Recommendation Report for Planning Permission for Works or Extension to a Dwelling

REF NO: **AW/48/15/HH**

LOCATION: 16 Barrack Lane
 Aldwick

PROPOSAL: Rear 1st floor extension and rear single storey extension.

sheet 2 of 5

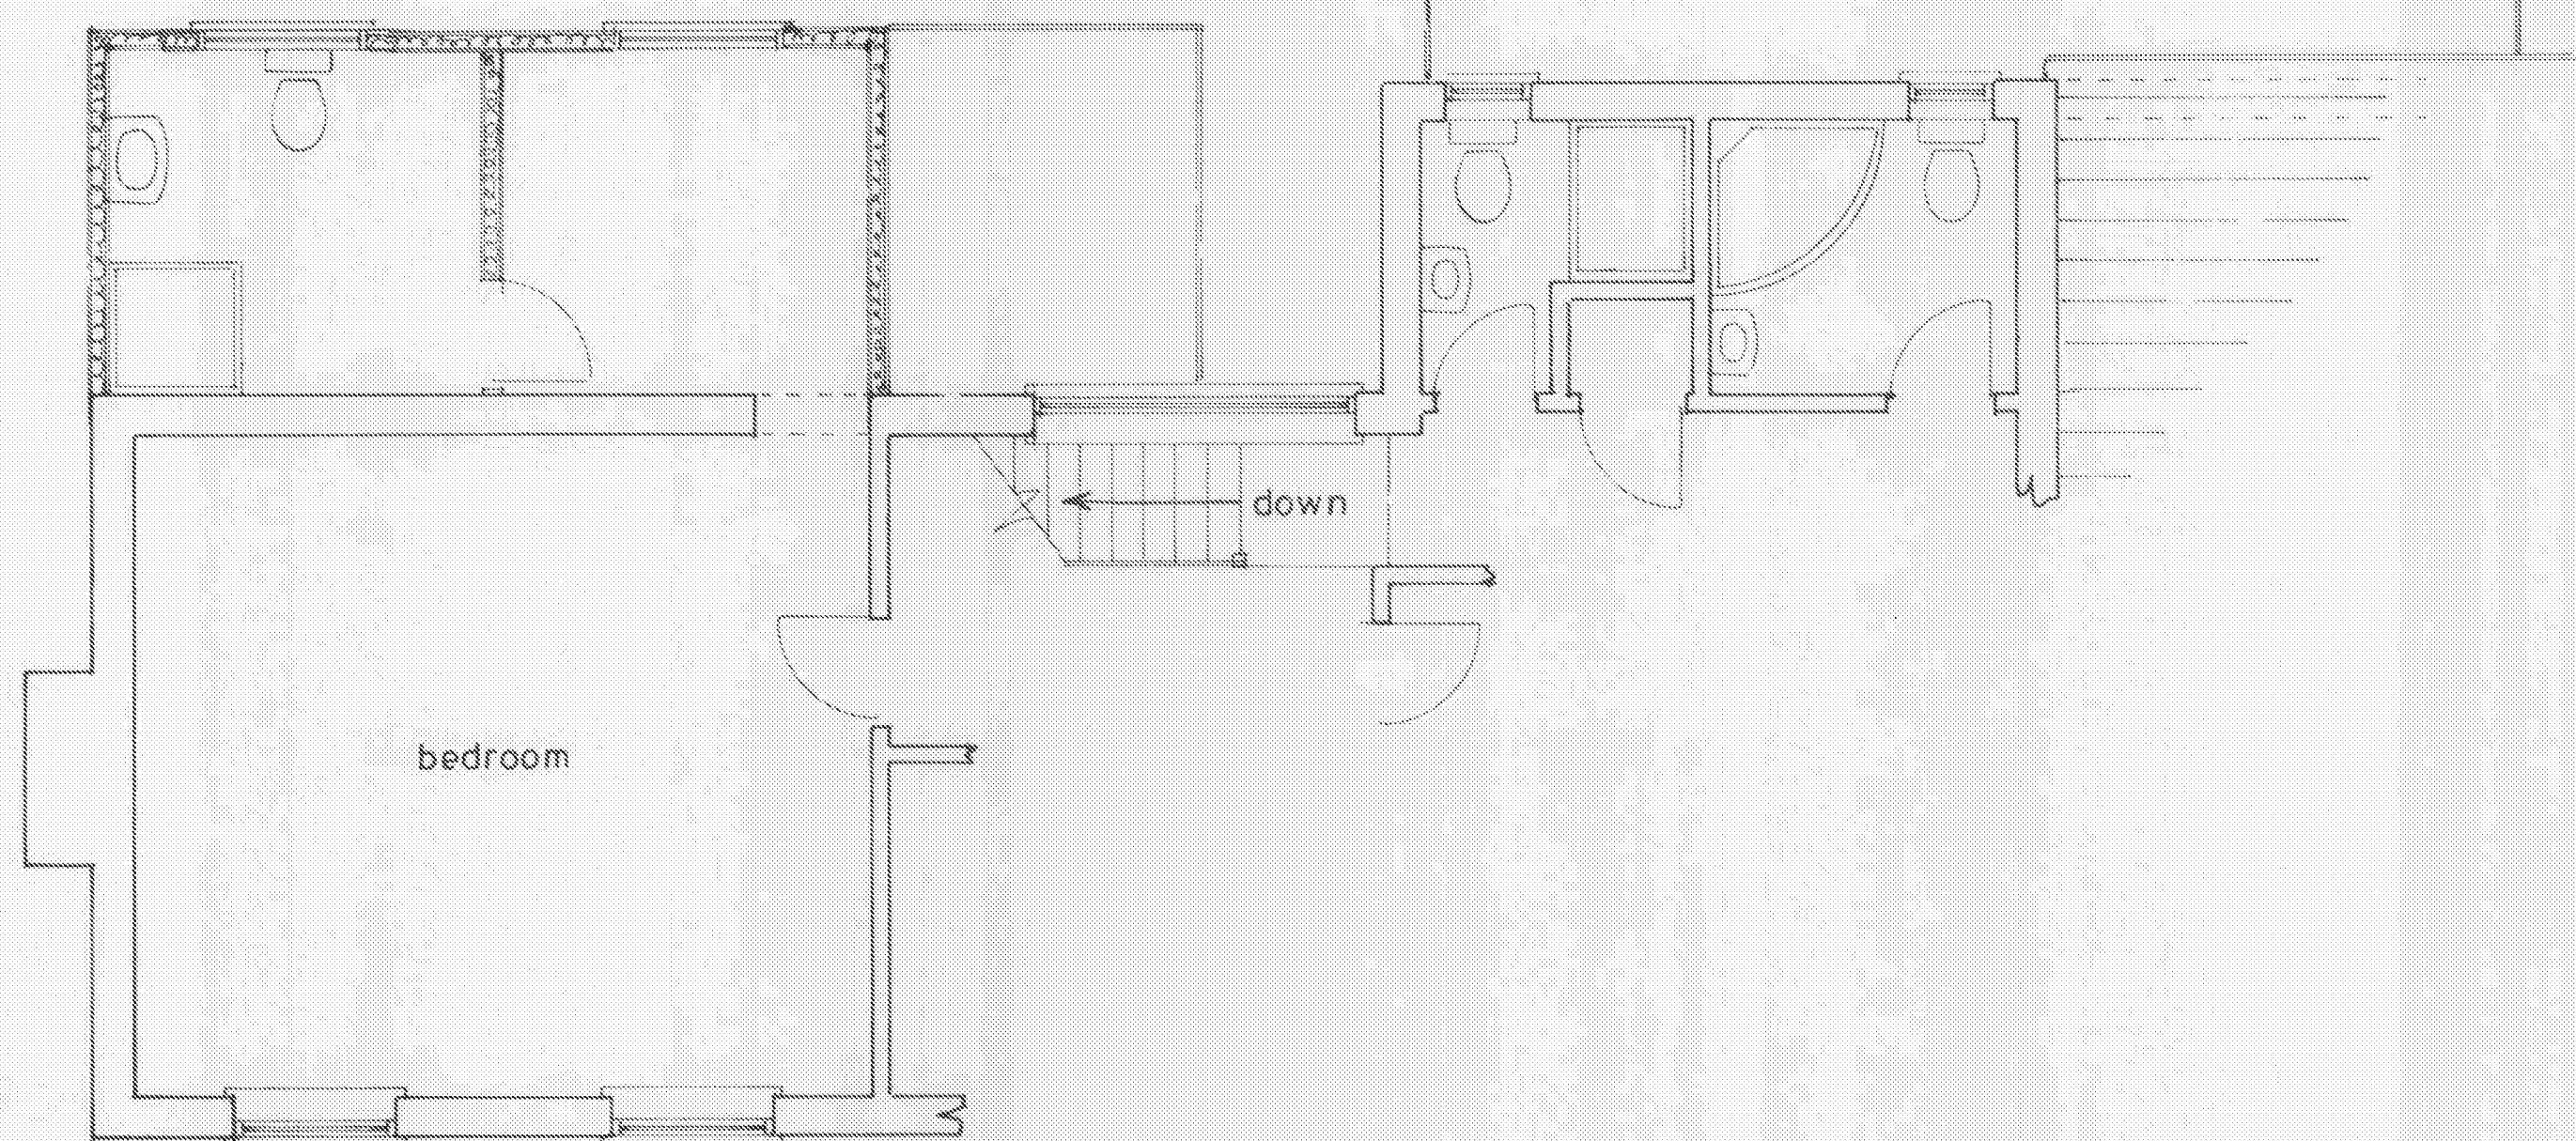
The host property is already set back from number 18 and the first floor element would be 9m away and has no proposed side windows. As such this element of the proposal would not result in demonstrable harm through overlooking, an overbearing impact or overshadowing to the neighbour amenities of number 18.

A condition shall be included to prevent any further windows in the west side elevation of the first floor element to prevent any undue overlooking into the garden of number 18 in the future.

PROPOSED BOUNDARY WALL AT 16, BARRACK LANE, ALDWICK FOR MR. & MRS. T. KEET.

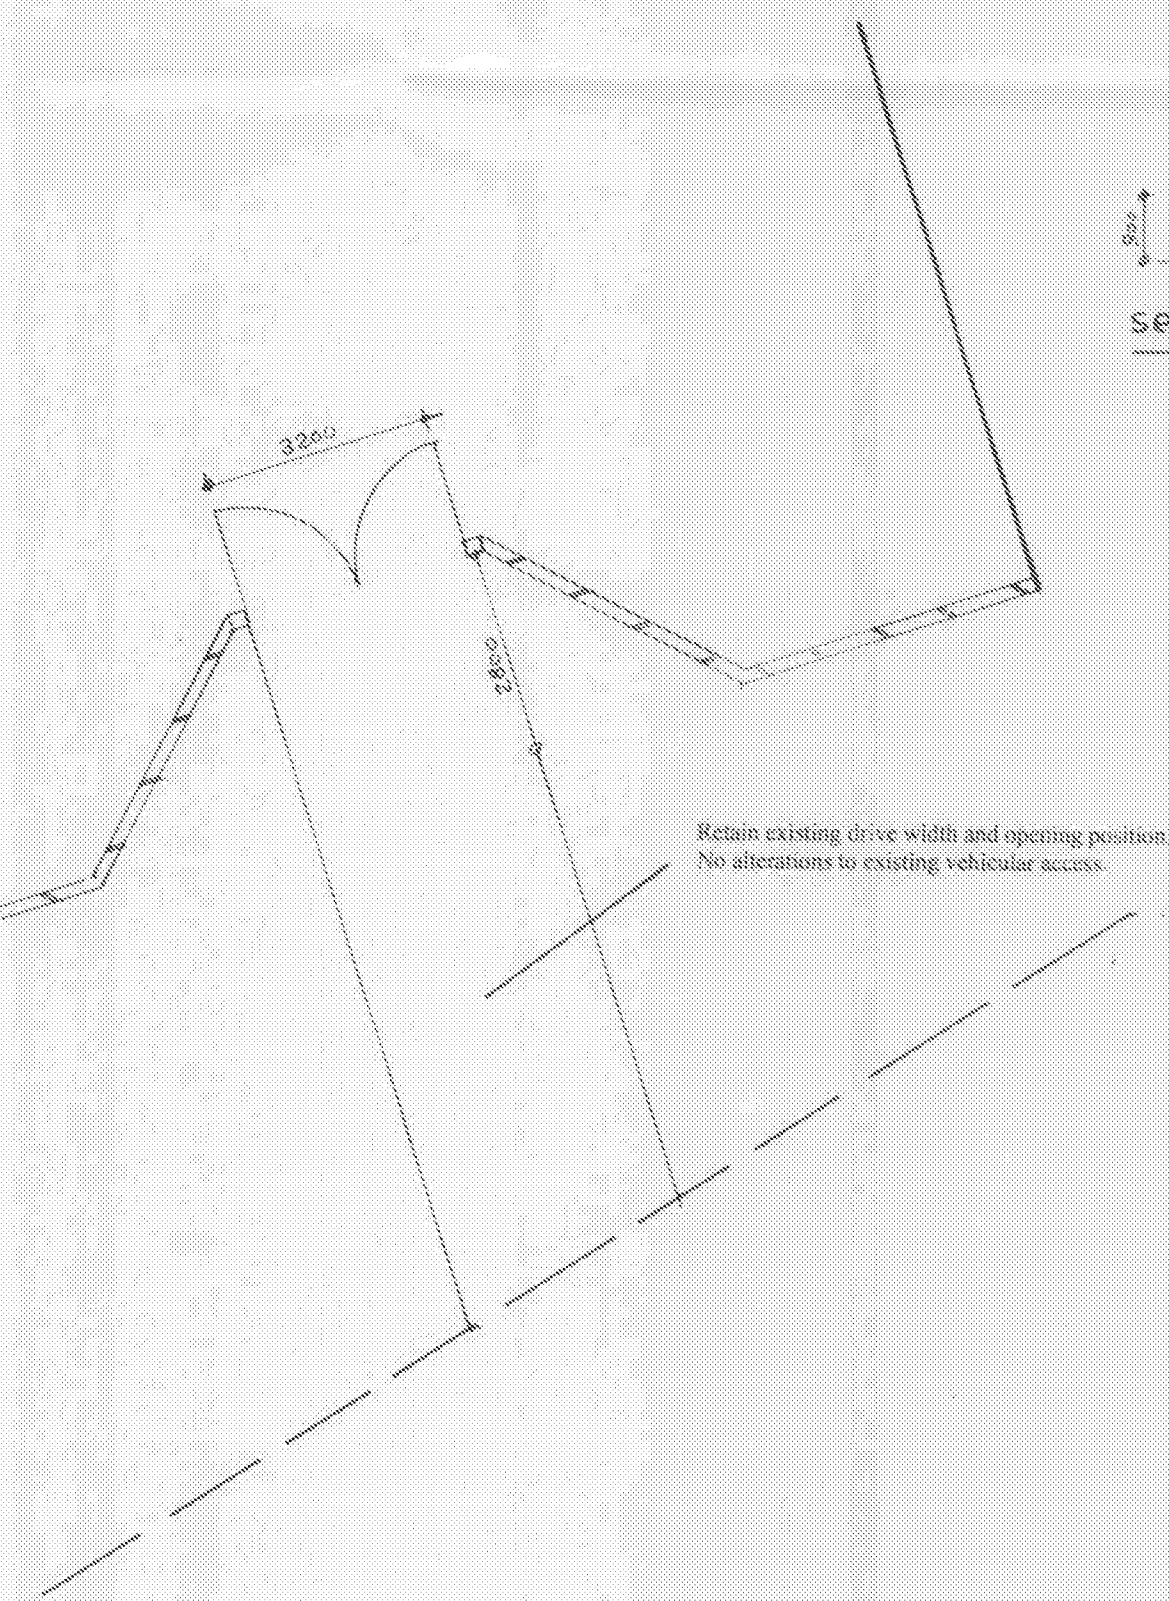
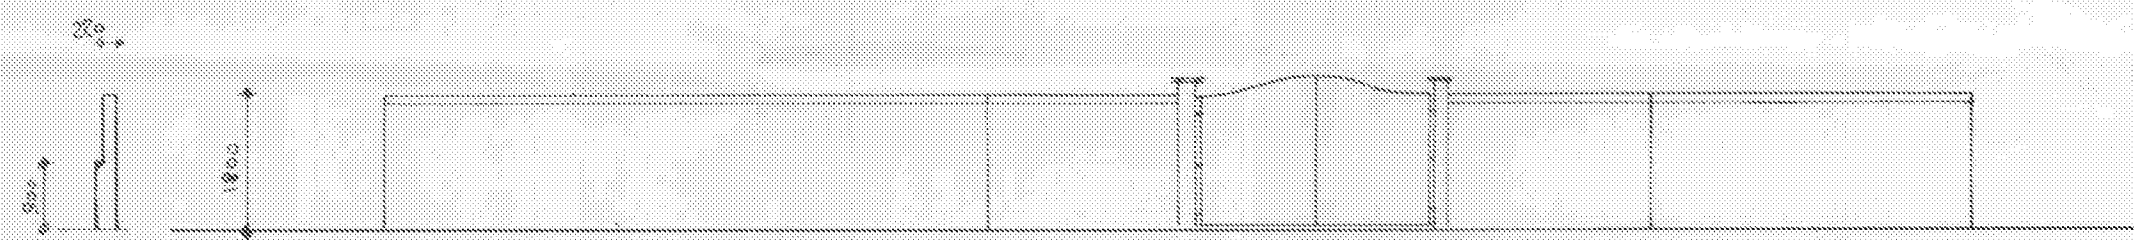
Objecting - loss of hedges and trees to the front of the site owing to the proposed wall. Concerns were also raised about the proposed 1.8m boundary wall (which has now been omitted from the scheme) not being in character with the road.

- From the submitted plans, there appears to be a possible conflict between the proposed construction process, and the respective RPA's of the established trees on site. This is most apparent for the proposed boundary wall, which from the submitted plans would appear to intrude into the RPA's of the established trees in the along the front boundary of the site.

The objections to the proposed front wall have been resolved by the omission of this element of the proposal.

Following the omission of the front wall element of the proposal, no trees will be harmed or removed by the proposal so tree objections have been addressed.
